# CITY OF ALBUQUERQUE

September 9, 2022

**RE: Petroglyph Plumbing  
3031 Painted Rock NW  
Grading and Drainage Plan  
Engineer's Stamp Date: 07/22/2022  
Hydrology File: G10D029**

Based upon the information provided in your submittal received 07/26/2022, the Grading & Drainage Plan **is not** approved for Grading Permit. The following comments need to be addressed for approval of the above referenced project:

PROJECT NAME
GRADING AND DRAINAGE PLAN

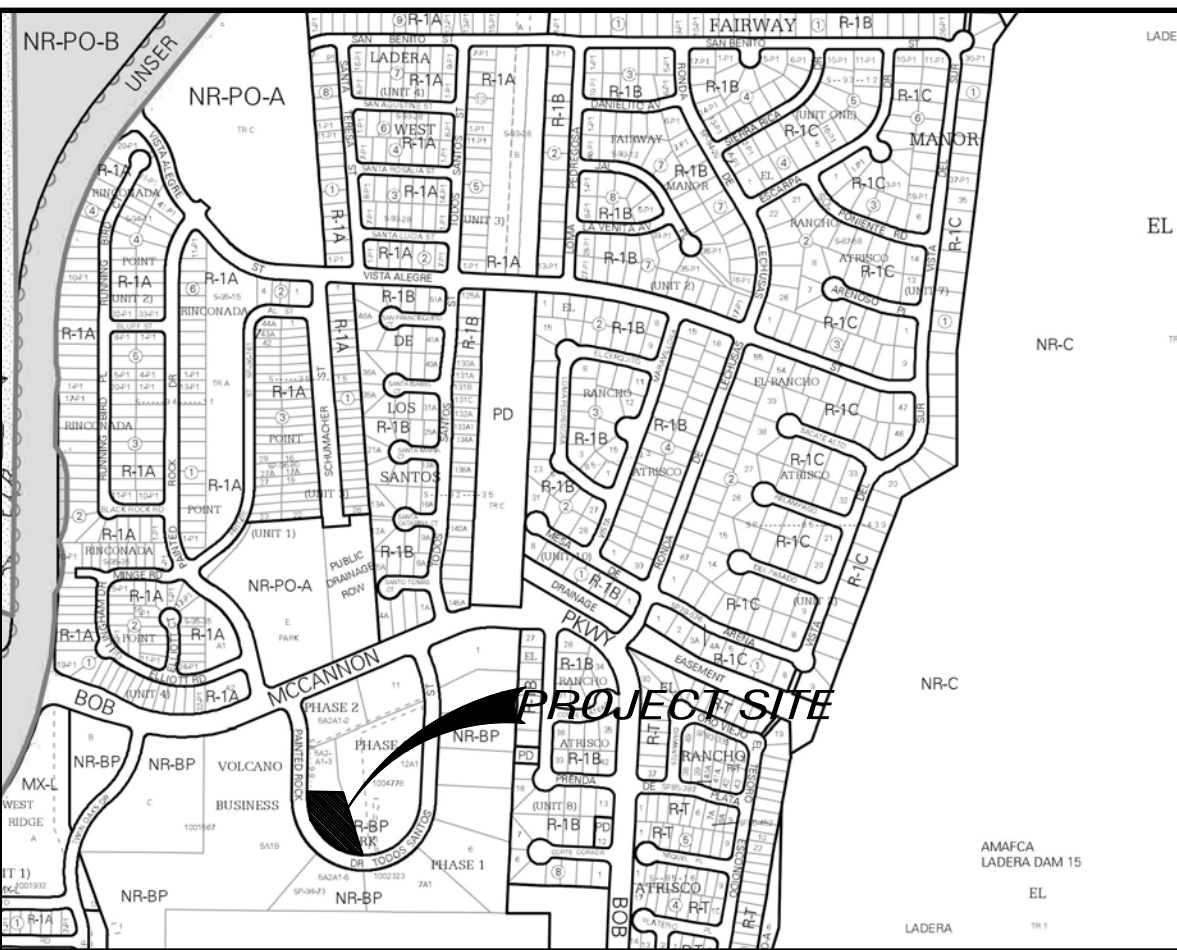
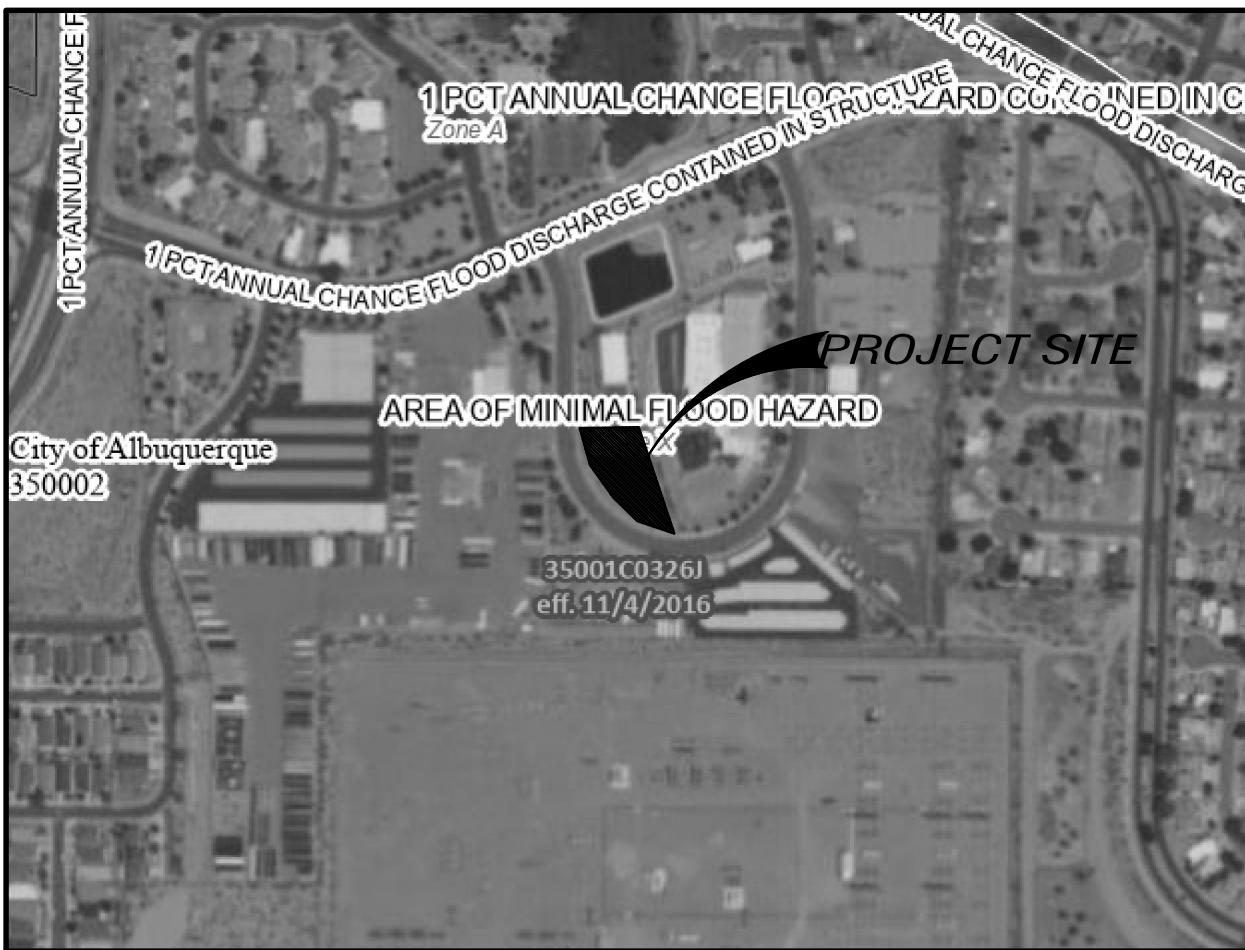
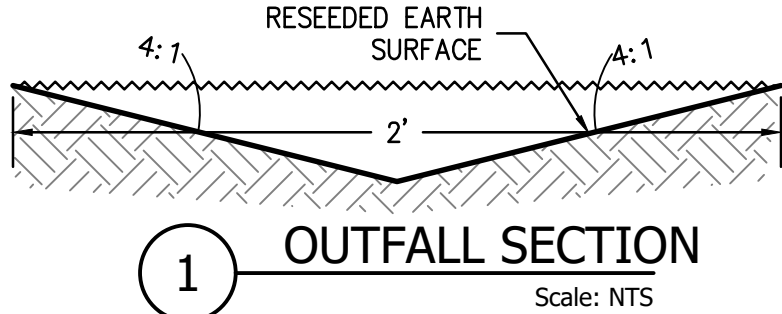
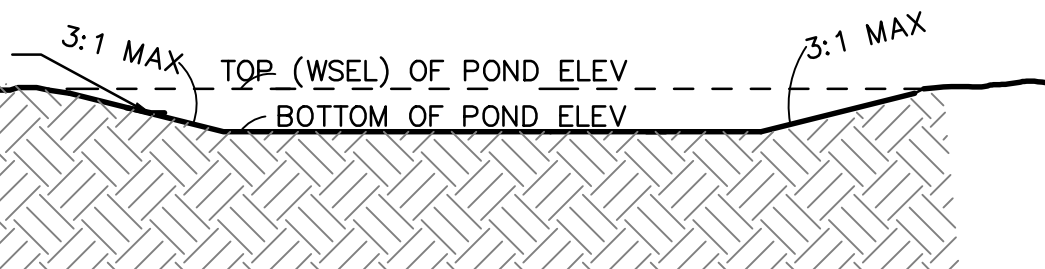
1. Please check drafting. Example, the sidewalk goes all the way through the driveway. Explain/clarify or please remove this.

- a.
2. Please review calculations. If you are providing detention, you will need to create calculations for detention and include 24 hour storm calculations and provide detention volume for that and provide flow limitations.
3. Please show where the pond spills out. There is currently no information on how this will discharge.
4. A waterblock, 0.87' high, per COA Paving Detail No. 2426, is required at the driveway entrance.
5. Please include survey points to show how the site ties into existing grades.
6. Is there a curb cut going into the pond? How does the water get to the pond?
7. It is not clear with what is presented how the site flows exactly. More information will help clarify (e.g. points at flowline along parking lot – and call out slopes).
8. How does this work/flow? I see TC elevations meaning this ponds here? Unclear.

12. Where does this section belong to on the plan?
